Your Ref. JPT/CH/6754
Our Ref. 28th January 2014
Date

Re: Application A/138/13 – Outline Application for erection of a detached dwelling house.

BLOCK PLAN
Scale 1:500

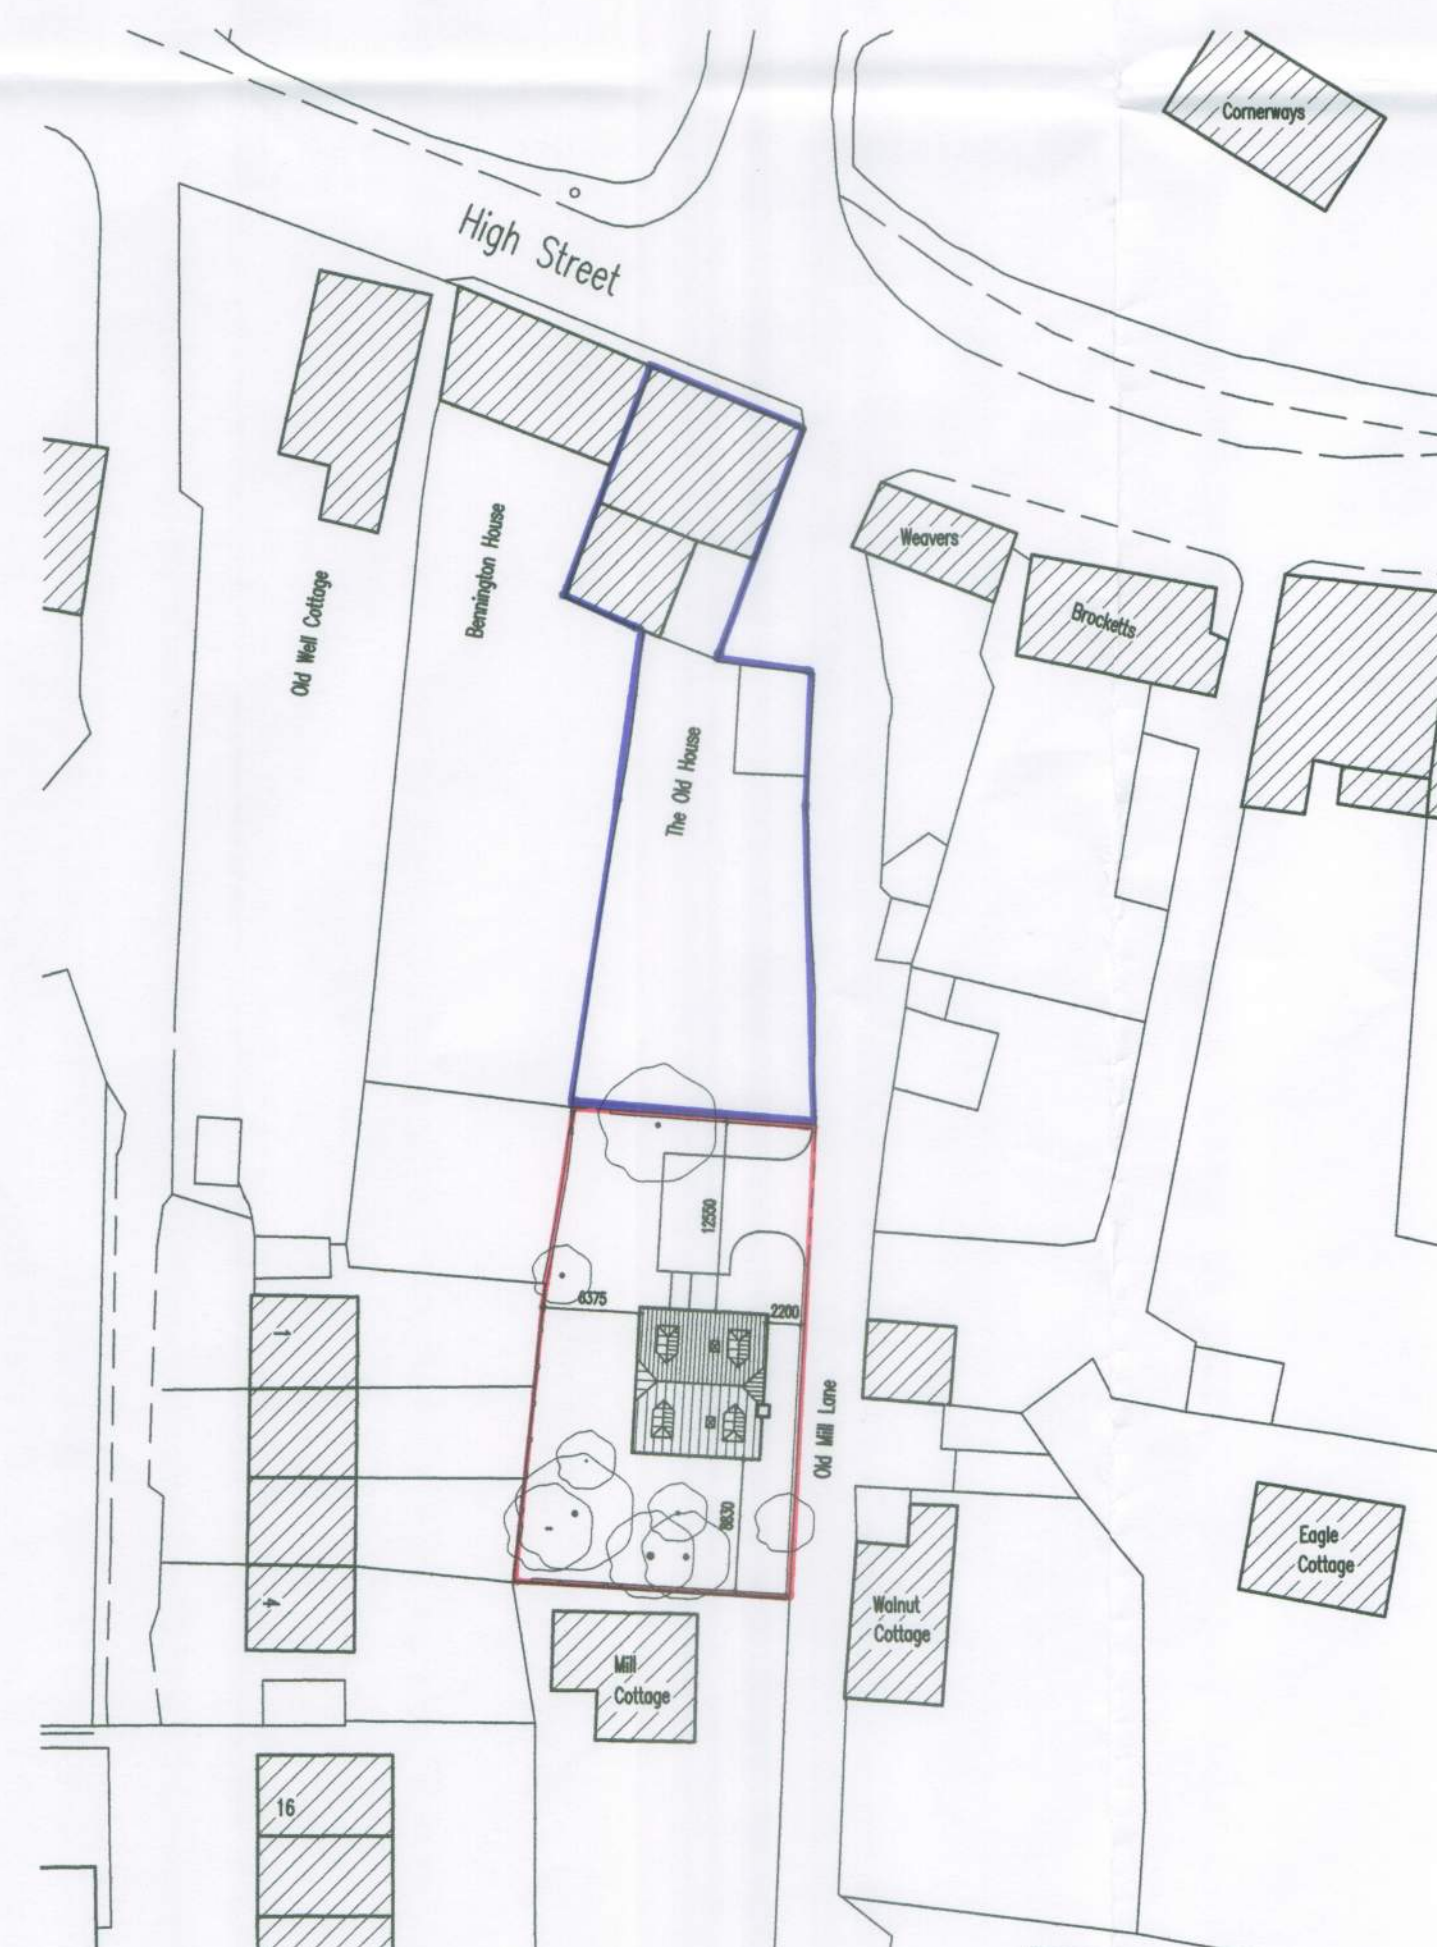
1. The block and site plans are in error as No. 1 Anchor Cottages has a rear single storey extension of 2M which is not shown.
2. The distance from the proposed dwelling to the rear of No. 1. Anchor Cottages is not 18M it is 16.4M. Therefore the site survey plan 1275/PO2 submitted with the application is in error on this point and on point 1. above.
